**Consultation Response from KC,
Highways Development Management****2024/92063 45a, St Helen's Gate, Almondbury, Huddersfield, HD4 6SG****Conversion and extension of dwelling to form 8 apartments (within a Conservation Area)****Date Responded: 12-9-2024.****Responding Officer: Mark Berry.****Responding Ref: 11-5-12.**

This application seeks approval to the conversion and extension of a dwelling to form 8 apartments at 45a, St Helen's Gate, Almondbury. Huddersfield.

Development Plan

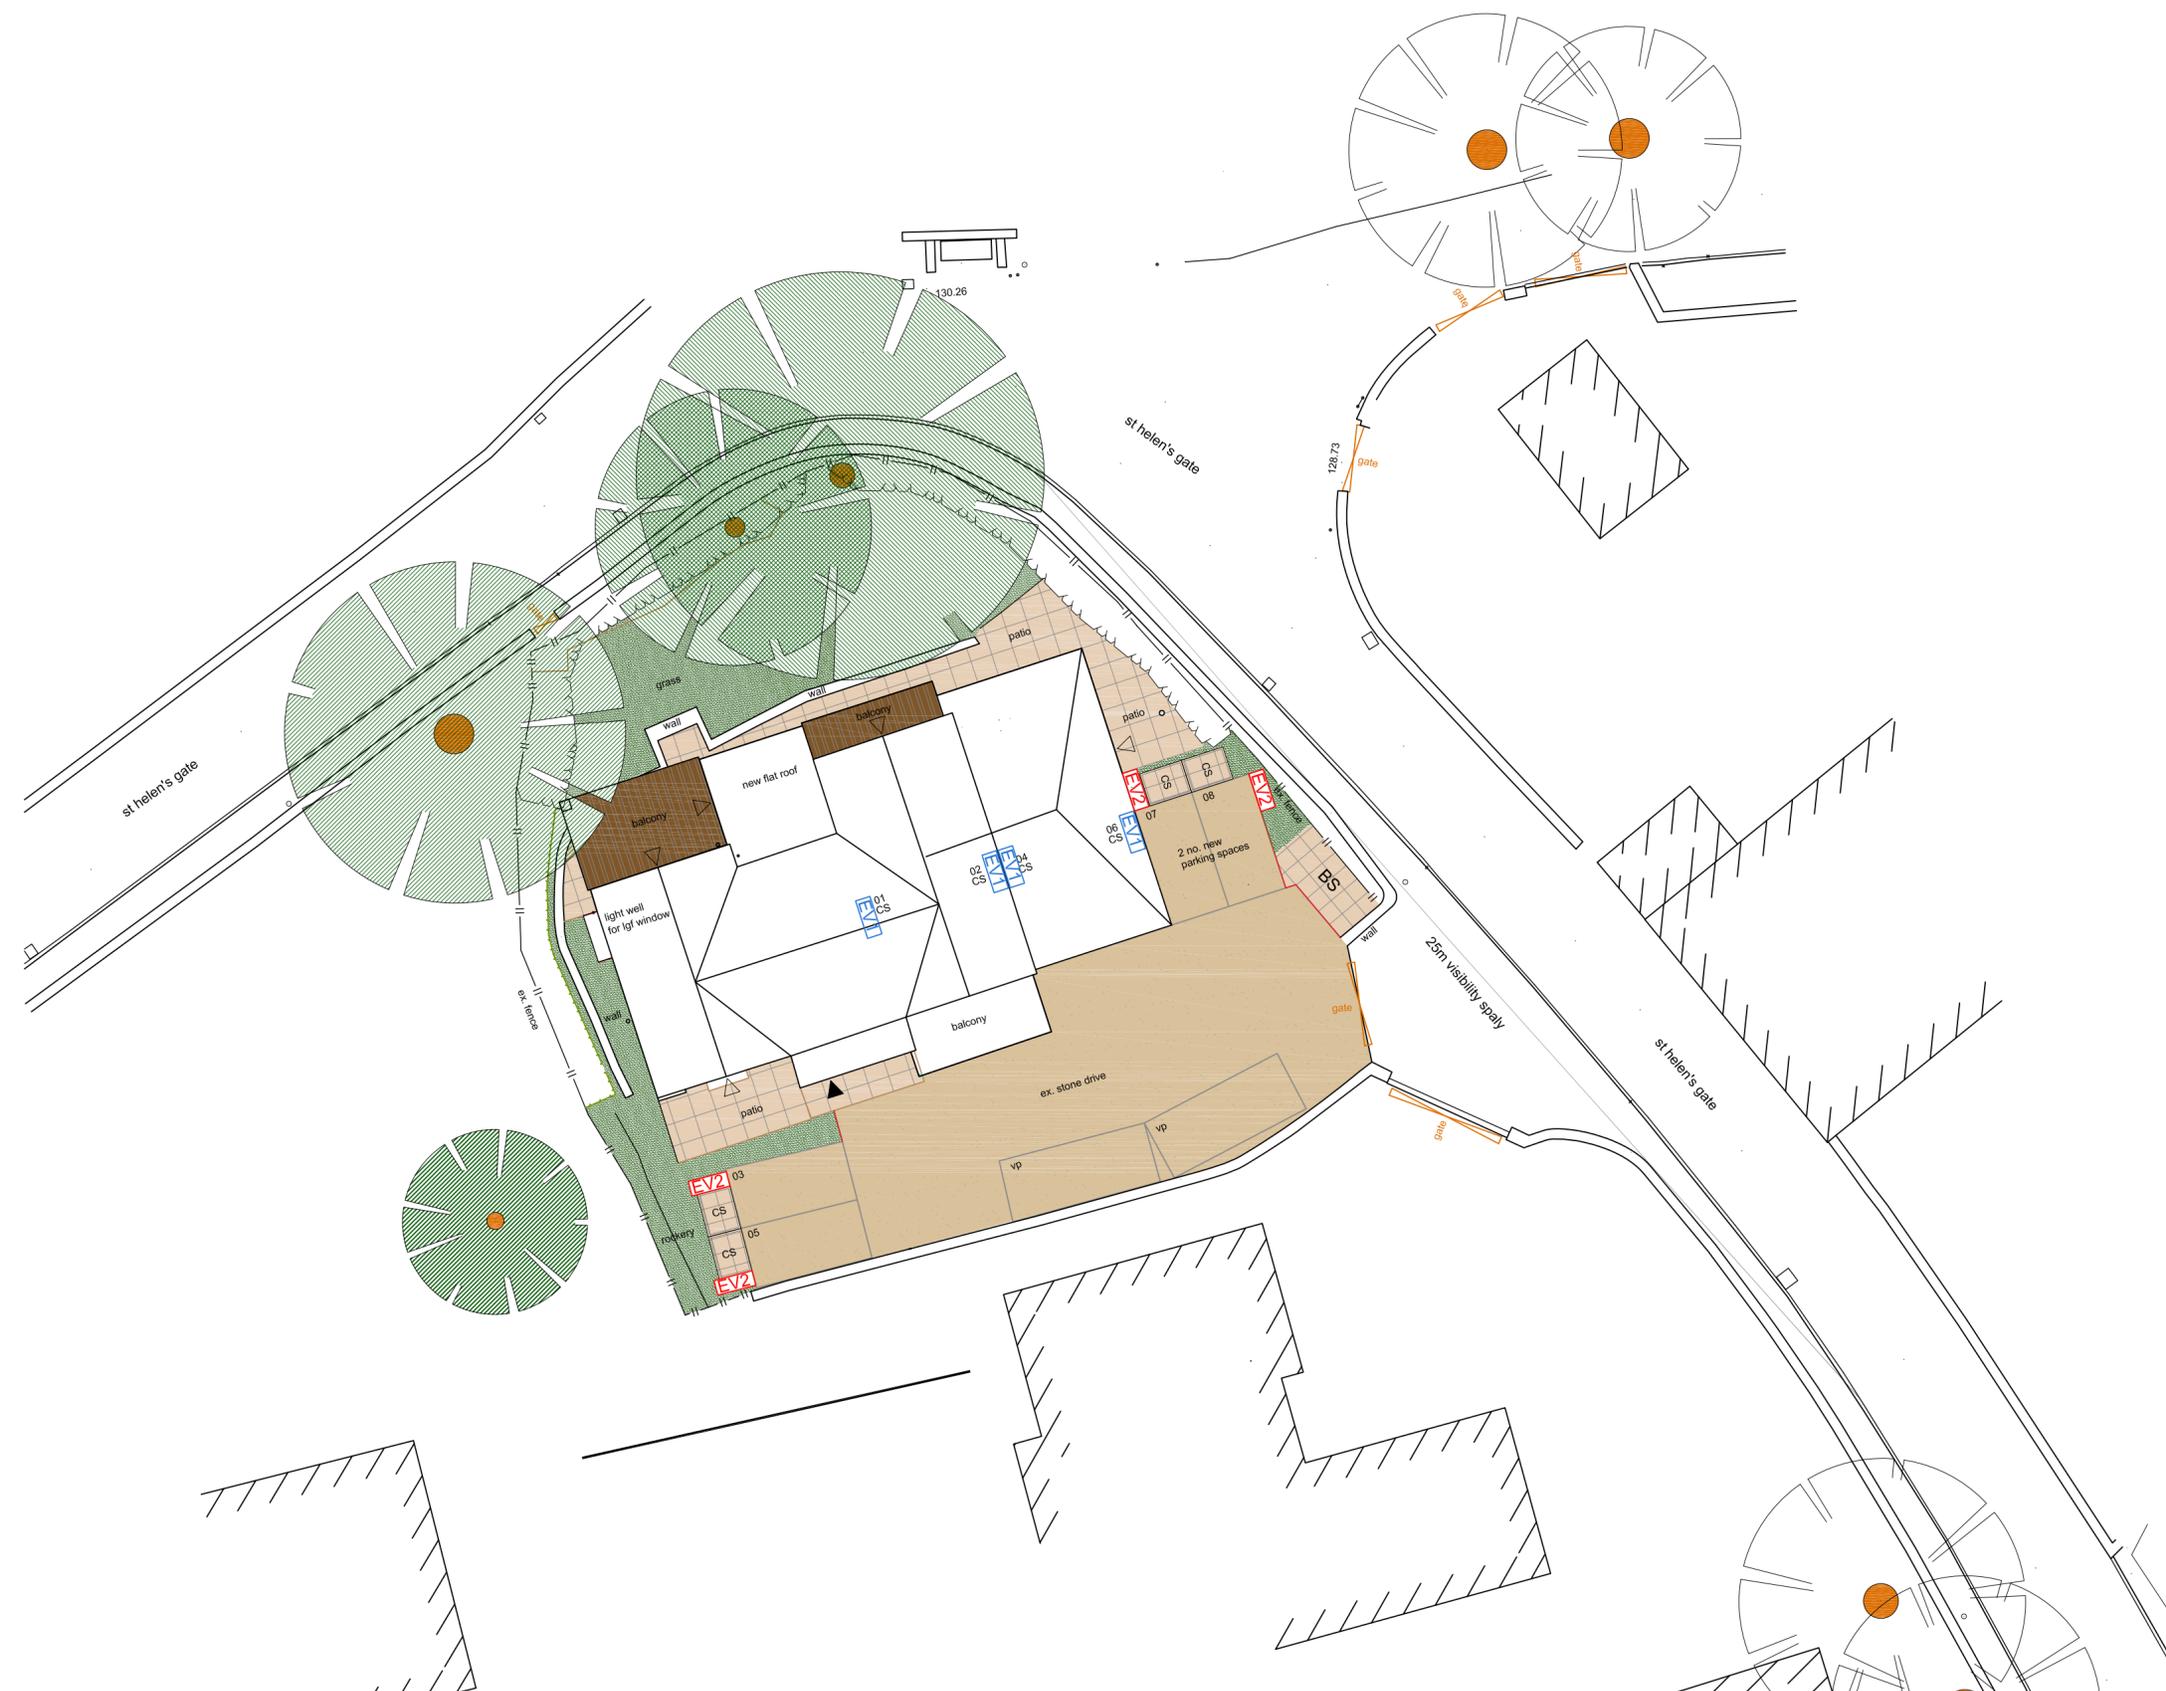
This existing driveway meets St Helens Gate at an angle resulting in difficult turning and manoeuvre, the access is only 3.5m wide which is not enough to allow two vehicles to pass and visibility from the access on to St Helens Gate is poor in both directions.

This access is shared with the adjacent property Almondeberie House and inter-visibility between the two driveways is poor.

The location of the two proposed visitor parking spaces potentially obstructs vehicle turning movements resulting in difficult turning and manoeuvre into and out of the proposed residential parking spaces.

Four of the spaces are shown within carports. Central pillars towards the front of these spaces will make access difficult.

Access to parking spaces 7 and 8 being close to the access will also require difficult turning and manoeuvre.

Highways Development Management (HDM) consider that this proposal results in over-development of the site with cramped and difficult turning manoeuvre into and out of parking spaces. This could potentially result in vehicles needing to park on St Helens Gate which is not in the best interests of highway safety.

The access is narrow which can potentially result in vehicles waiting on St Helens Gate, the angle it meets St Helens Gate results in difficult turning and manoeuvre and visibility from the access on to St Helens Gate is poor in both directions. This access is sub-standard and not suitable for any intensification in use.
